Application Reference: 2025/0088

Location: 52 Garden House Close, Monk Bretton, Barnsley, S71 2ED.

This application seeks planning permission for the erection of a two-storey extension to the side and the installation of a dormer window to the rear.

Drawing Title
PROPOSED GROUND AND
FIRST FLOOR PLAN

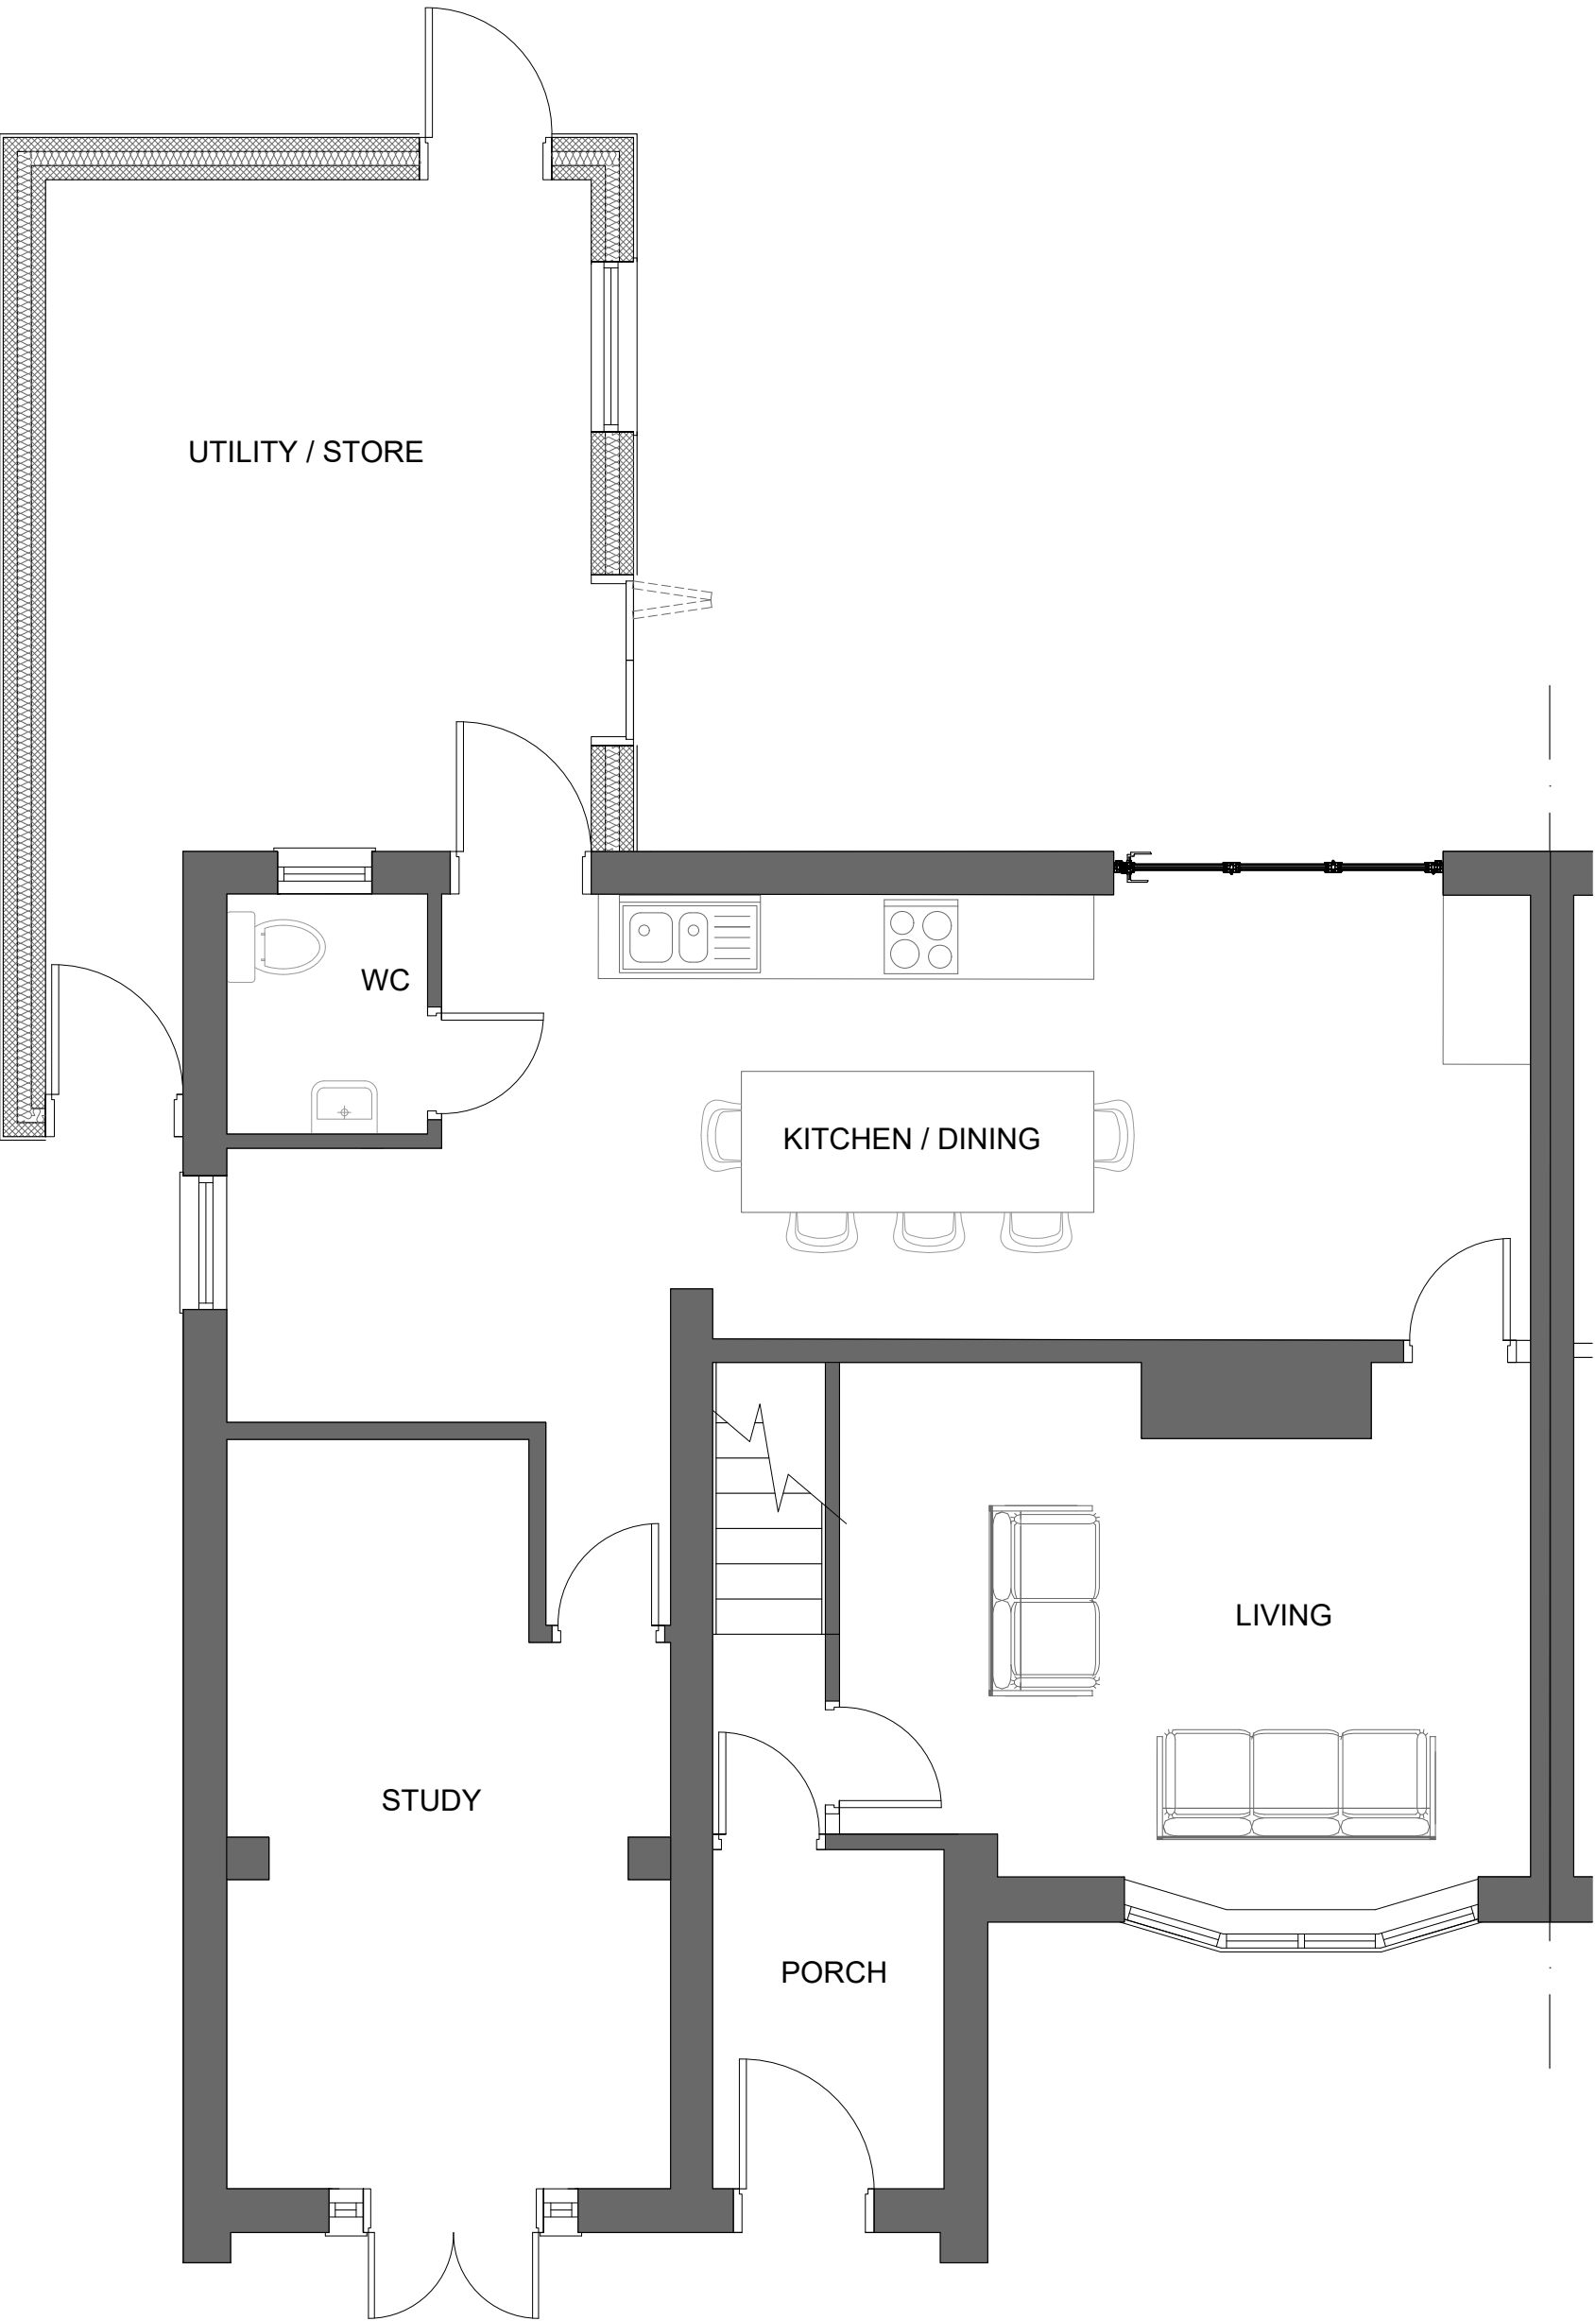
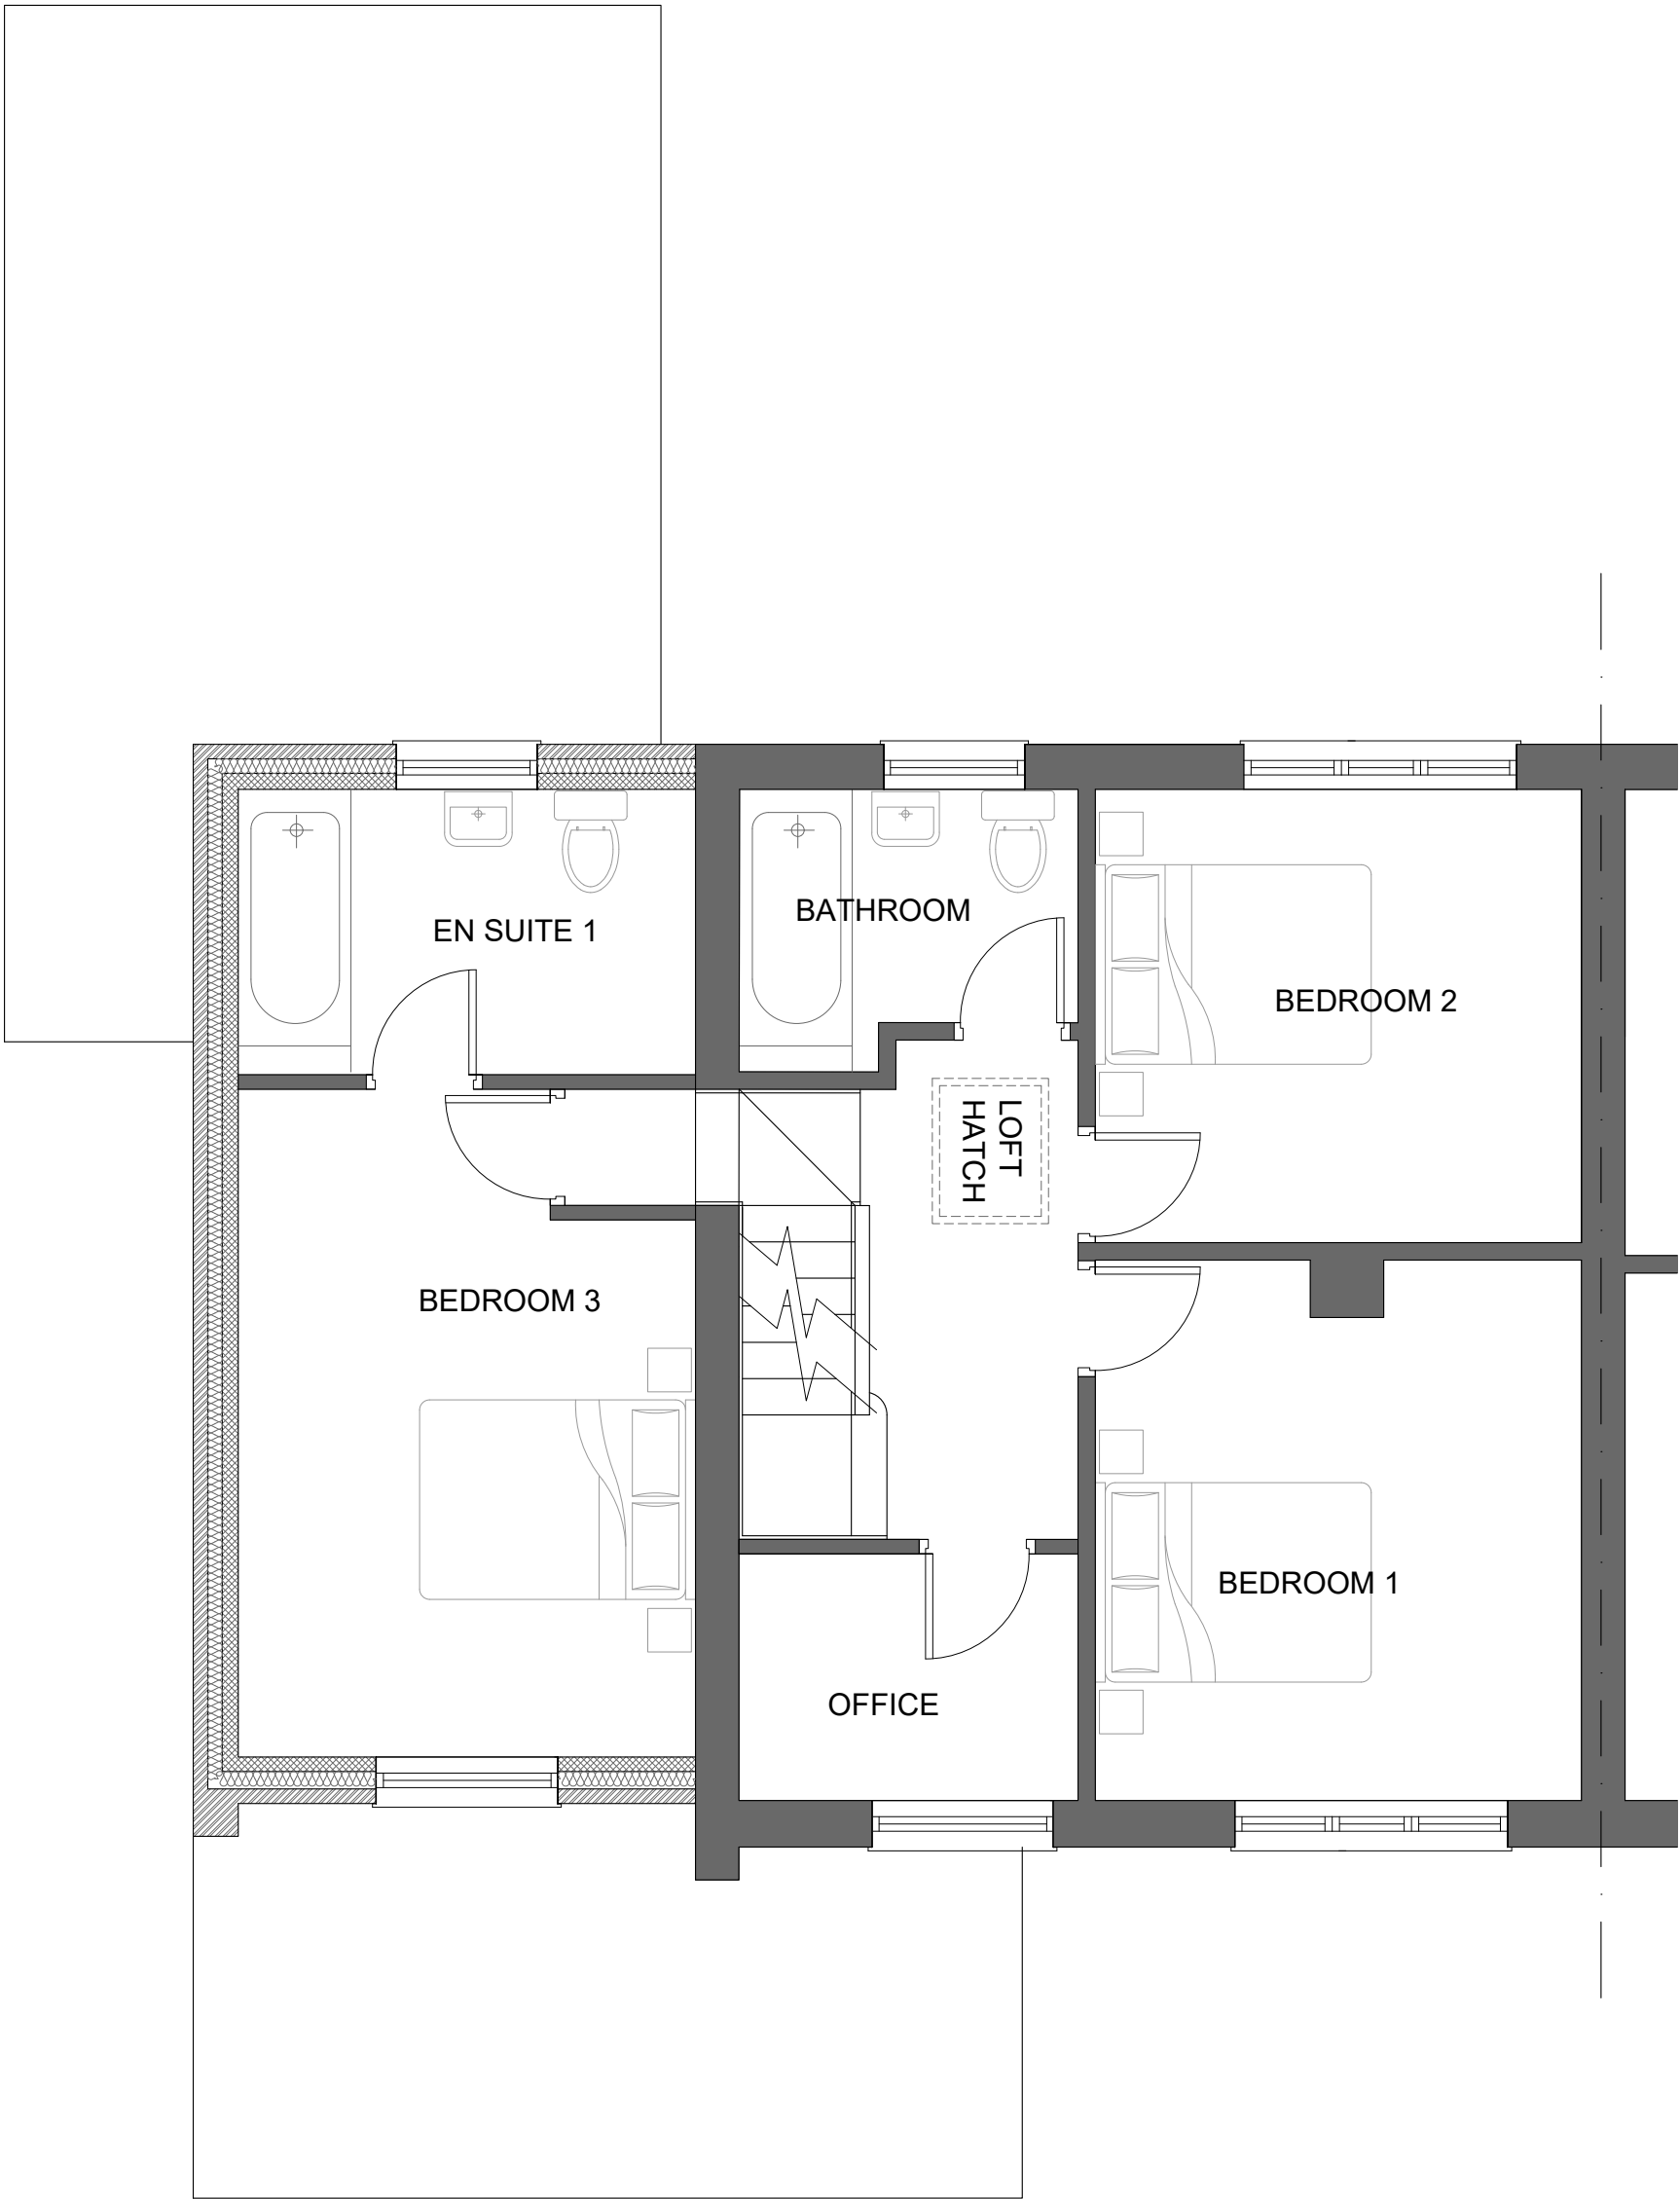
The proposed first-floor side extension would be erected atop and existing side extension to form a two-storey extension and would measure approximately 7.4 metres (L) x 3.4 metres (W) x 7.5 metres (H). The extension would be constructed of closely matching external materials.

Regarding overlooking and loss of privacy, new windows would be located on and limited to the front and rear elevations of the proposed extension and dormer window. A sufficient separation distance of approximately 14 metres would be maintained to the rear boundary and approximately 29 metres to the rear habitable room windows of neighbouring properties on Butter Cross Park, in accordance with the Council's design guidance. The presence of high conifers along the rear boundary line would continue to provide some screening and lessen the extent of any potential impact.

During the application process, the proposal was amended to set the extension down and back, alter the materials of the dormer window, remove a second dormer and align openings.

Drawing Title
PROPOSED SECOND FLOOR
PLAN AND SITE PLAN

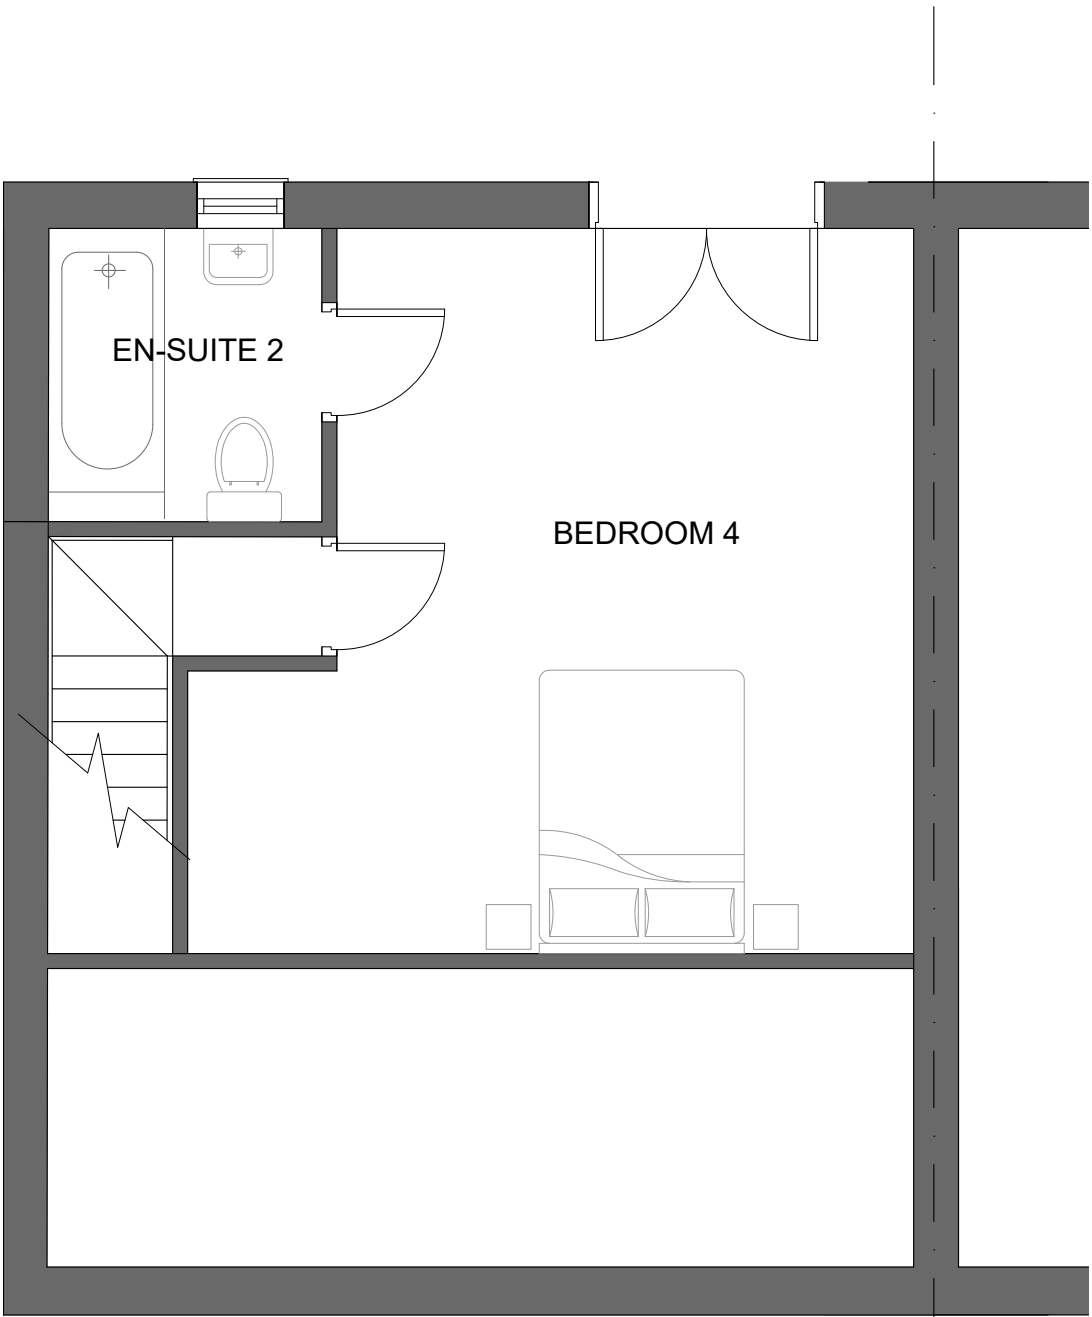
The proposed rear dormer window would measure approximately 3.3 metres (D) x 6.1 metres (W) x 2.3 metres (H) and would be timber clad and painted anthracite grey.

In this instance, the proposed dormer window would be installed to the rear, and whilst it would adopt a relatively large scale, the dormer window would be set back from the original eaves and set below the original ridge. The proposed dormer window would be painted anthracite grey to sympathetically reflect the colour of existing roofing materials. The dormer window would be visible from Lamb Lane, but it would not appear as an overtly dominant or prominent feature within the street scene that could otherwise detract from its character and new apertures would align with existing apertures.
